CF/CF/JM
16258
4 July 2017

**RESPONSE TO SUBMISSIONS FOR SSD 5175 MOD 2
EASTERN CREEK BUSINESS HUB (LOT 2)**

Figure 2 – Location of the proposed loading dock

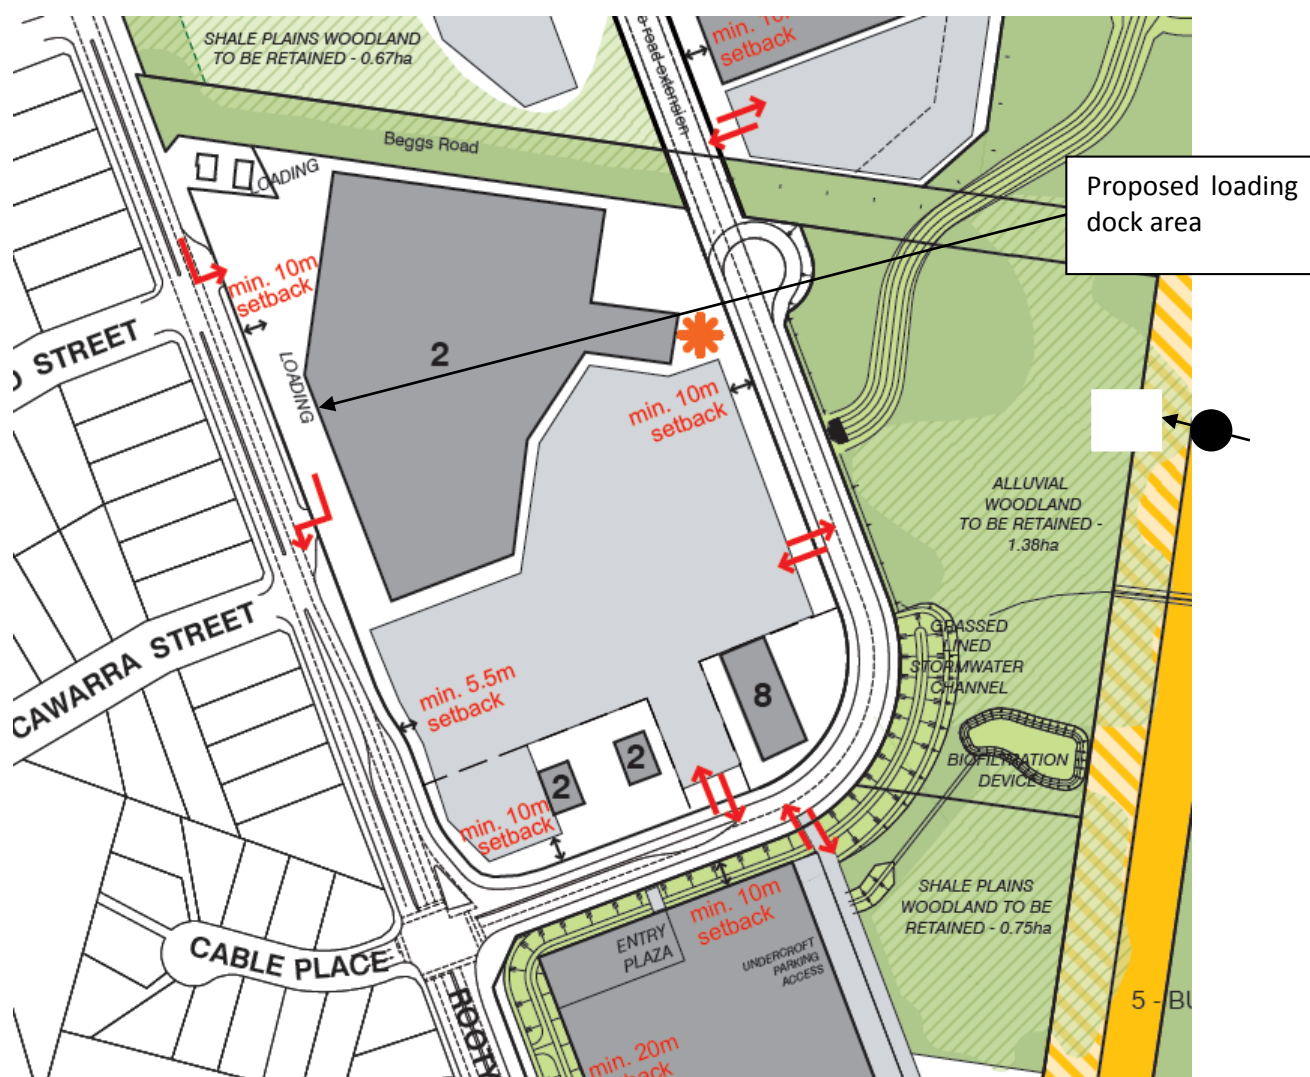
- *It is proposed immediately adjacent to the 2 dwellings on the corner of Rooty Hill Road South and Beggs Road, and is located opposite the low density residential area on Rooty Hill Road South. The loading dock activities will therefore impact on the amenity of these nearby dwellings in terms of visual impact, noise and odour.*

Acoustic Logic were engaged to undertake a preliminary assessment of the location of the loading dock on the nearby dwellings (refer **Attachment D**). The assessment confirms that the loading dock is capable of complying with the EPA Industrial Noise Policy and the Sleep Arousal Criteria for noise time operations. This will ensure the acoustic amenity of the worst affected residential receivers is protected. A full acoustic assessment will be undertaken for the detailed DA.

Figure 25: Preferred Indicative Layout

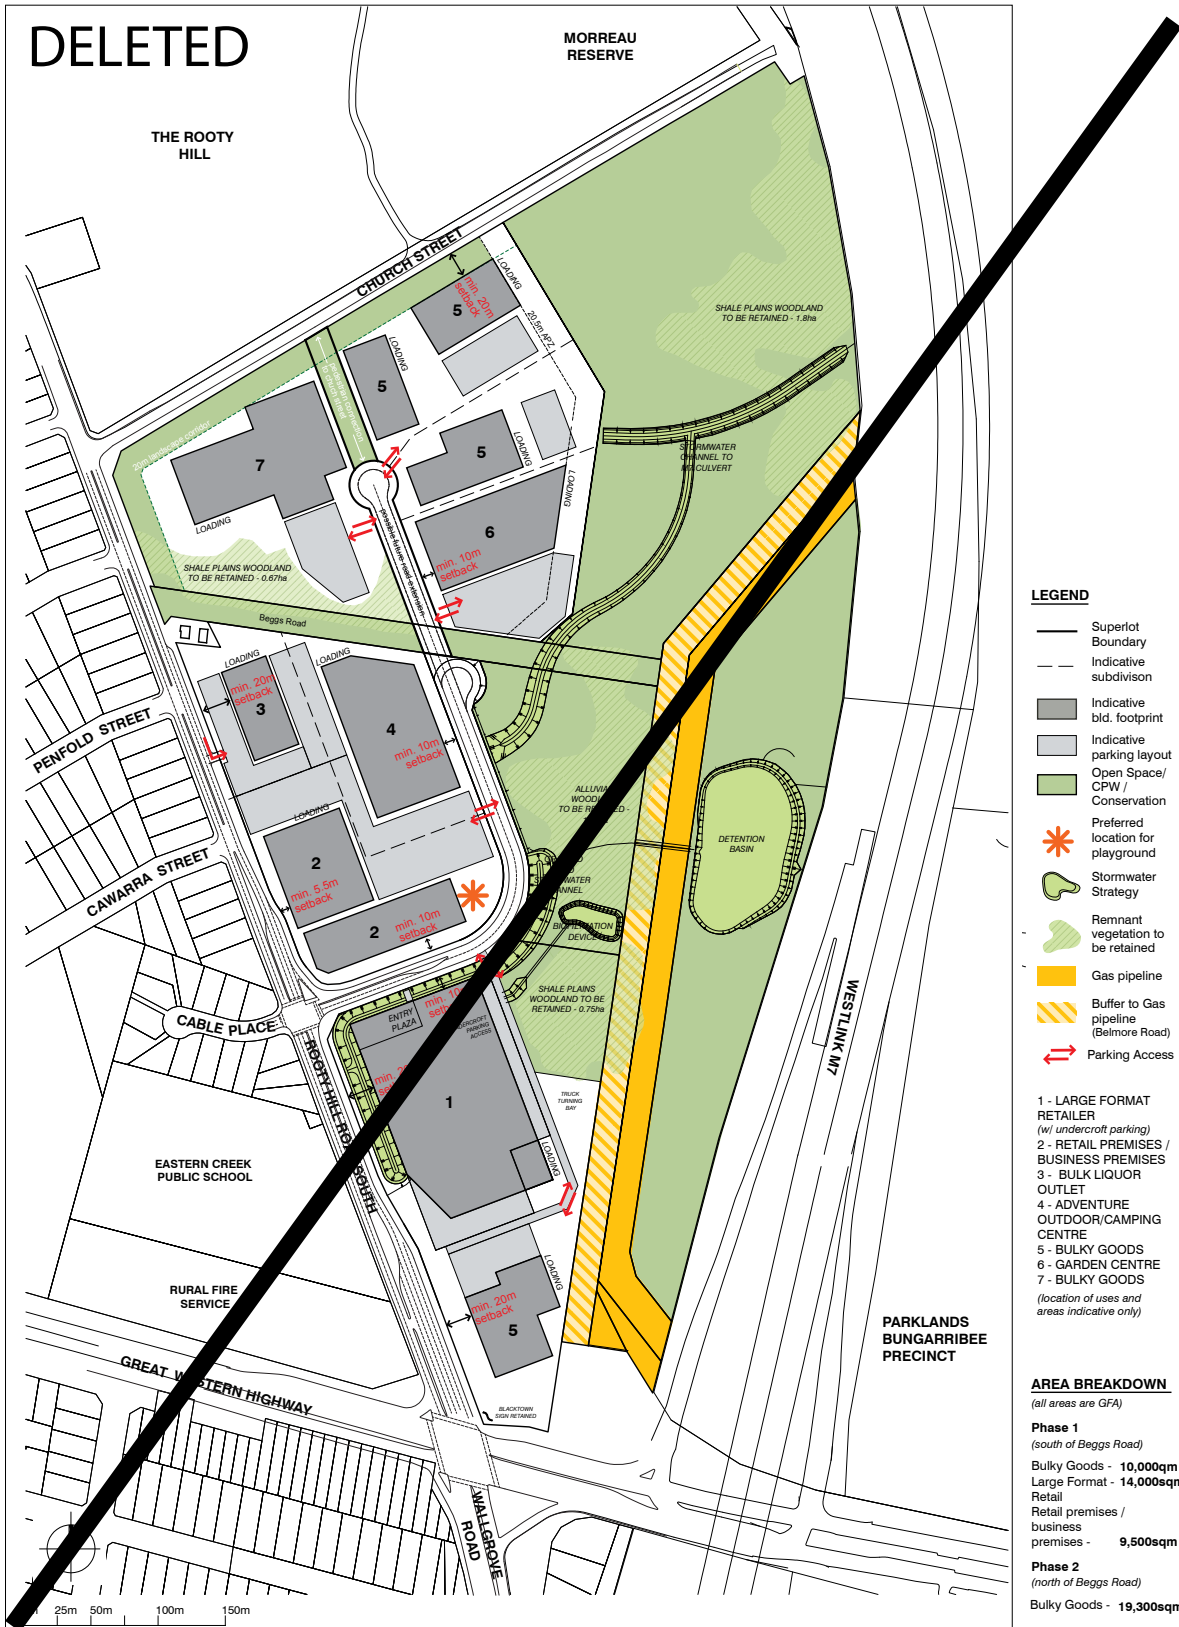
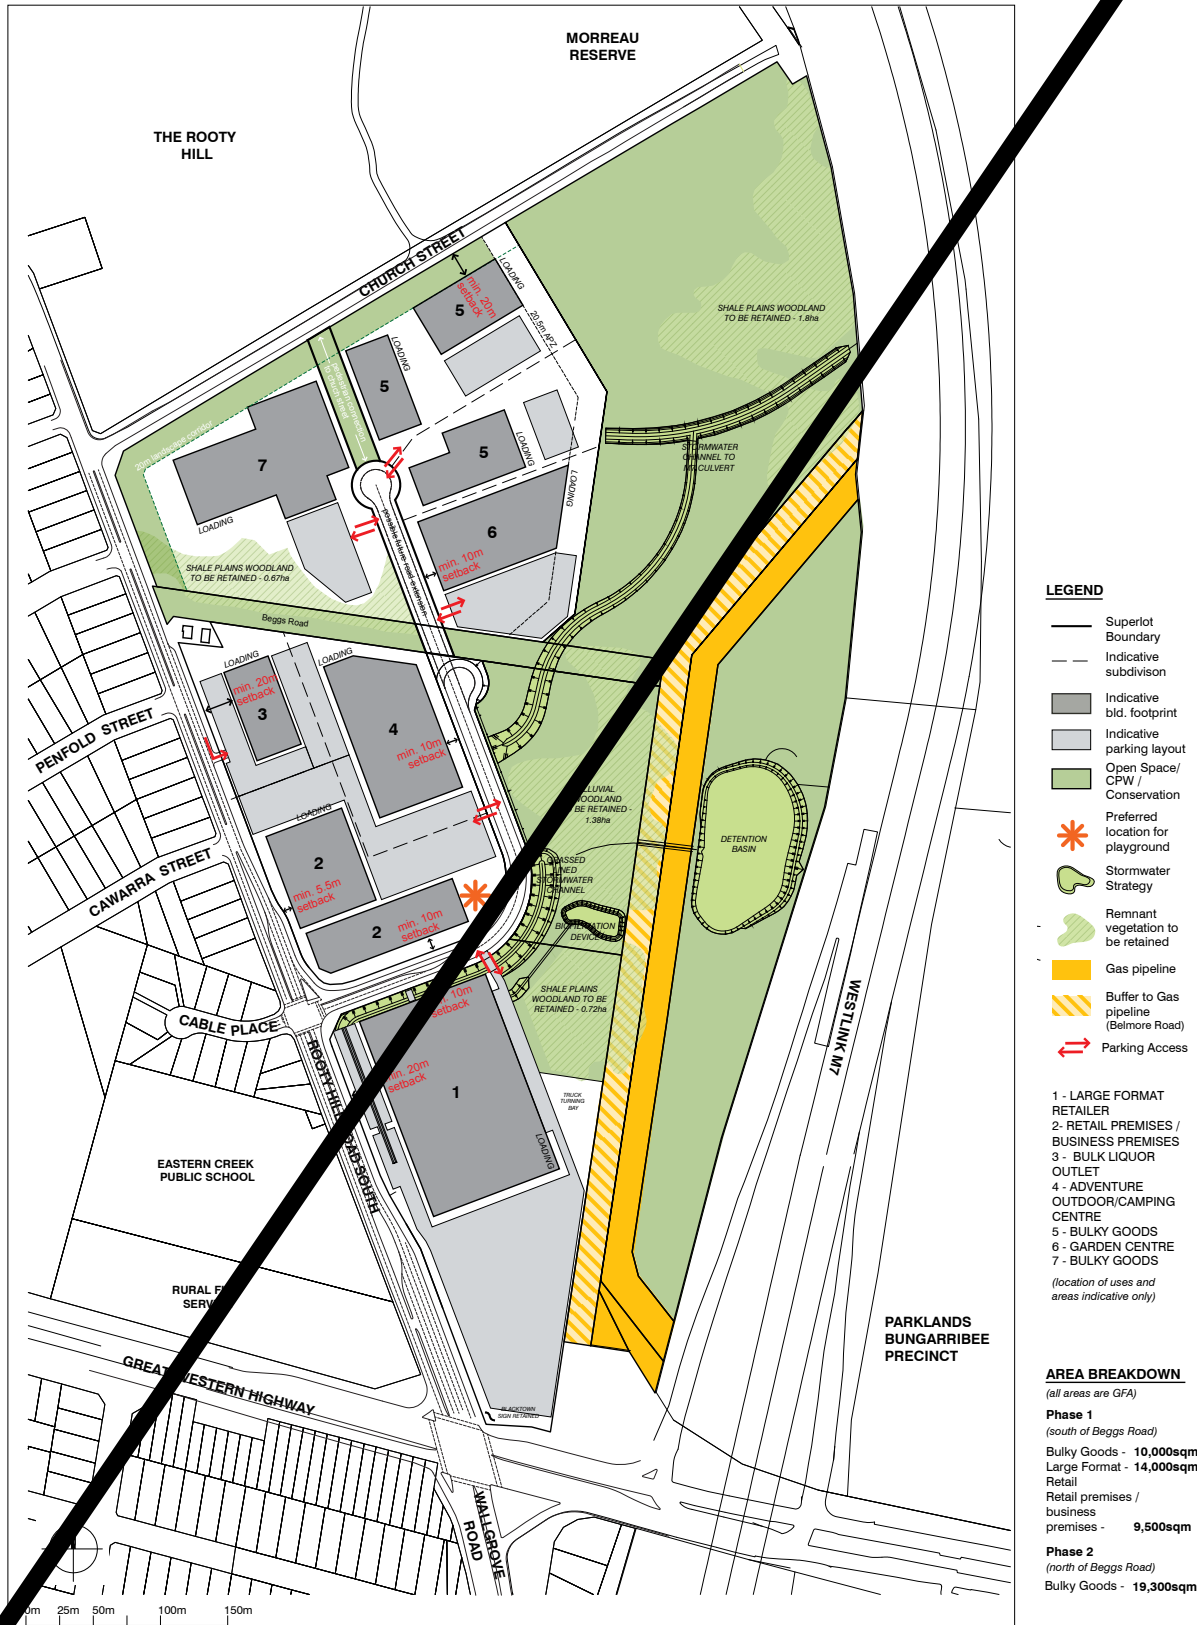
2.1 Urban structure The document should be updated to make reference to figure 25 on page 4-7- 27.	Guidelines have been updated to reflect this request.

Figure 30: Indicative Lot Subdivision Option 1

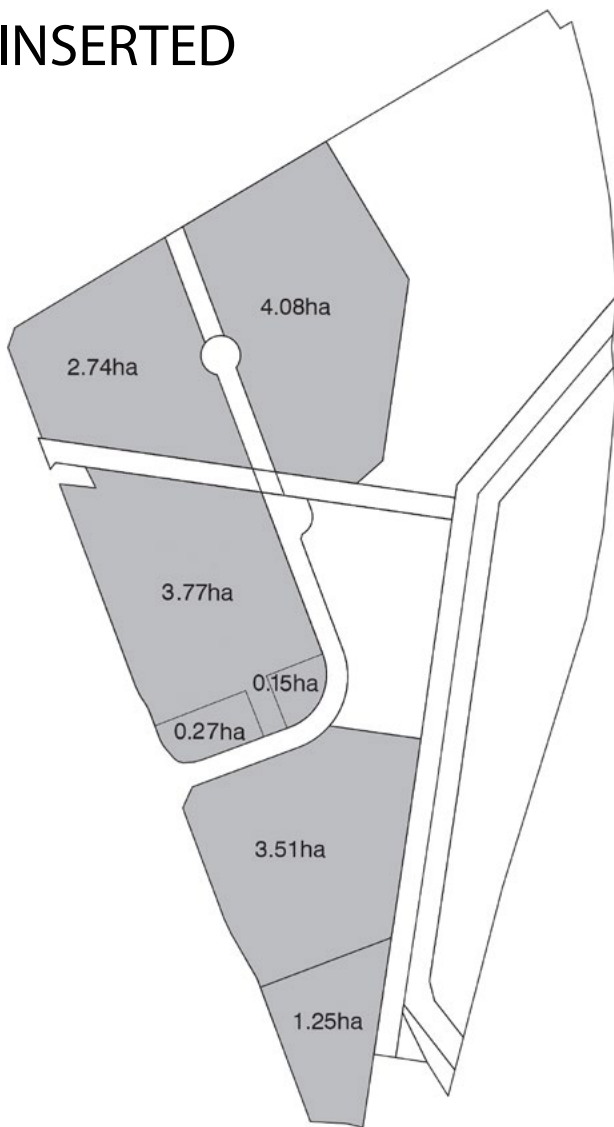
3.1 Subdivision design References to the minimum lot sizes have been deleted. These should be reinstated with the minimum lot sizes being consistent with those shown in figures 30 and 31.	Guidelines have been updated to reflect this request.

Figure 52: Development Control Plan - Lot 2 (not to scale)

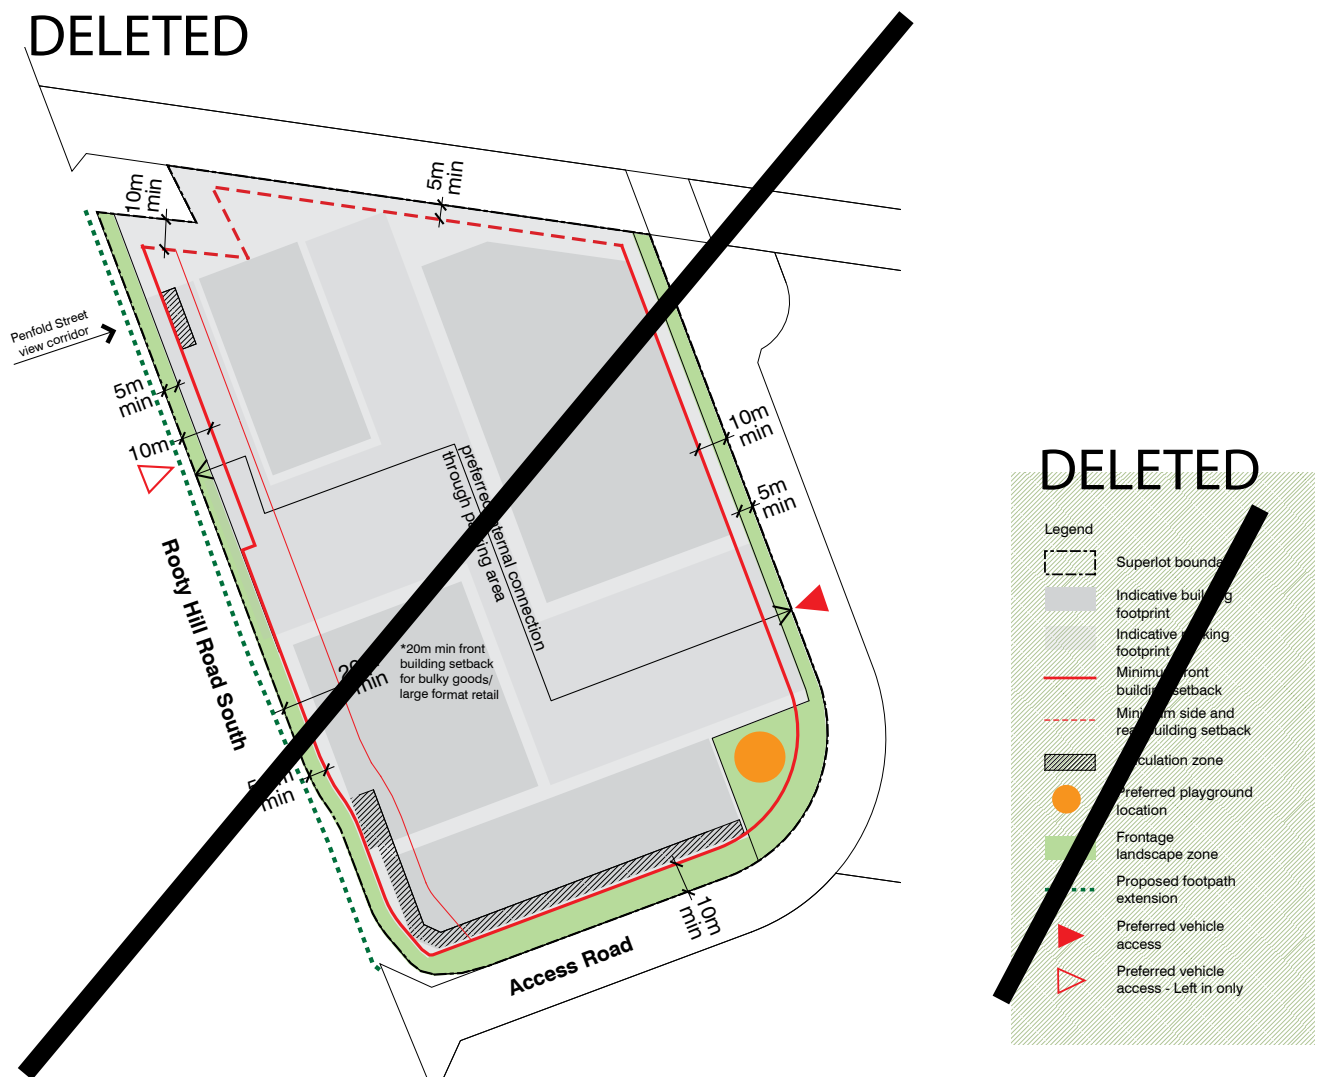
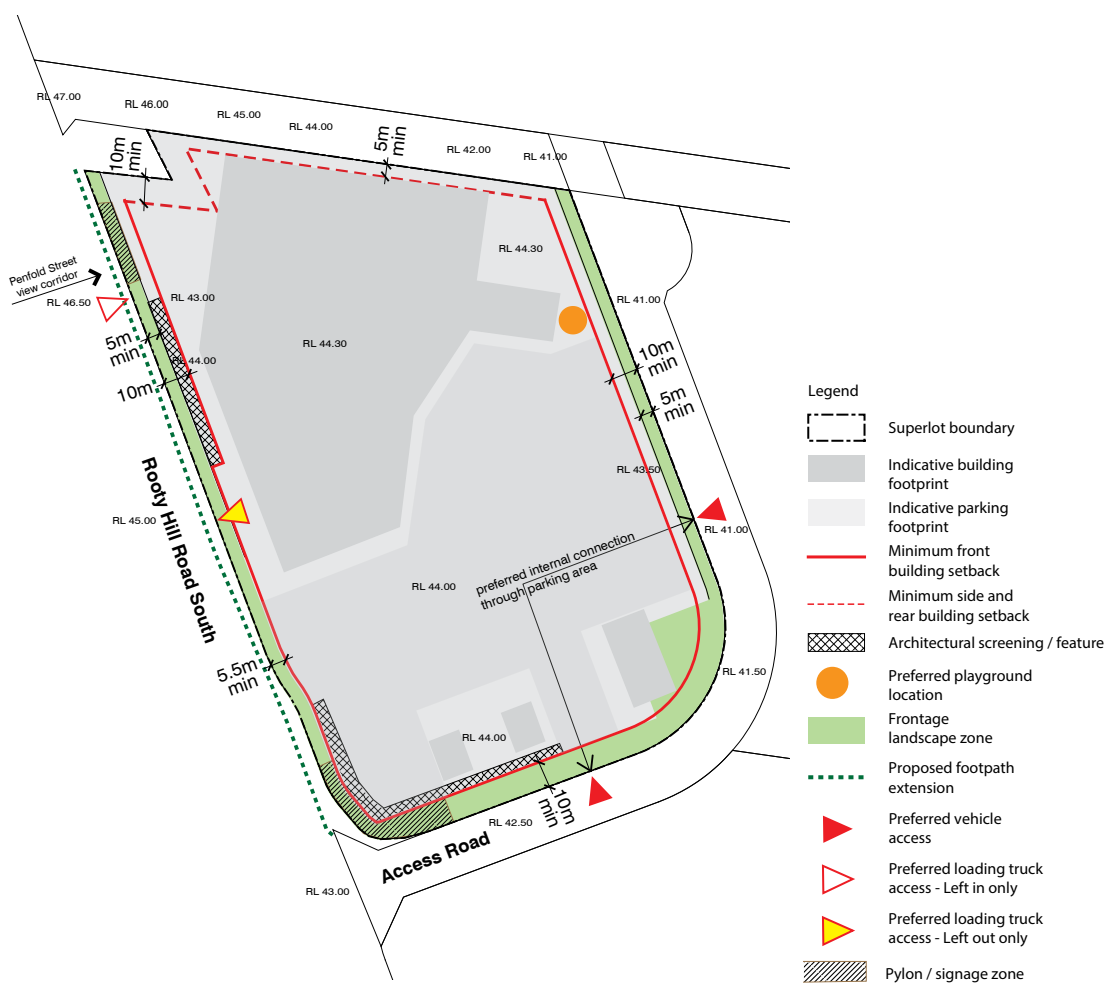
- *While a 5m setback has been provided to Rooty Hill Road South to accommodate screening and dense vegetation, no such allowance has been provided in the north-west corner of the site adjacent to the existing dwellings. A 5m setback is also considered insufficient given the scale of the development and the activities proposed.*

3.2 Access and circulation Control C2 requires that the loading areas are to be located behind the front building line. The proposed structure plan does not achieve this. The plan and design guidelines should be updated to provide a more appropriately located loading dock, which address the concerns outlined above.	This matter is addressed at Section 1 above. The reorientation of the site toward the parkland prevents the loading dock being located behind the building line. Nevertheless, any potential impacts such as noise and visual impacts can be appropriately mitigated.

A landscaped setback with a dimension between 5m - 10m is proposed along the loading dock boundary with the adjacent dwellings (refer to **Figure 3**). It is noted that the built form of the retail centre is setback a total of 23m (refer to **Figure 2** above). This plan has been updated within the Design Guidelines at **Attachment B** to reflect this change. As detailed above, the level difference between the sites, the proposed landscaped setback and acoustic wall all ensure that the residential amenity of the dwellings with regard to visual and odour impacts is maintained and will not appropriate outlook is maintained for the adjacent residential dwellings.
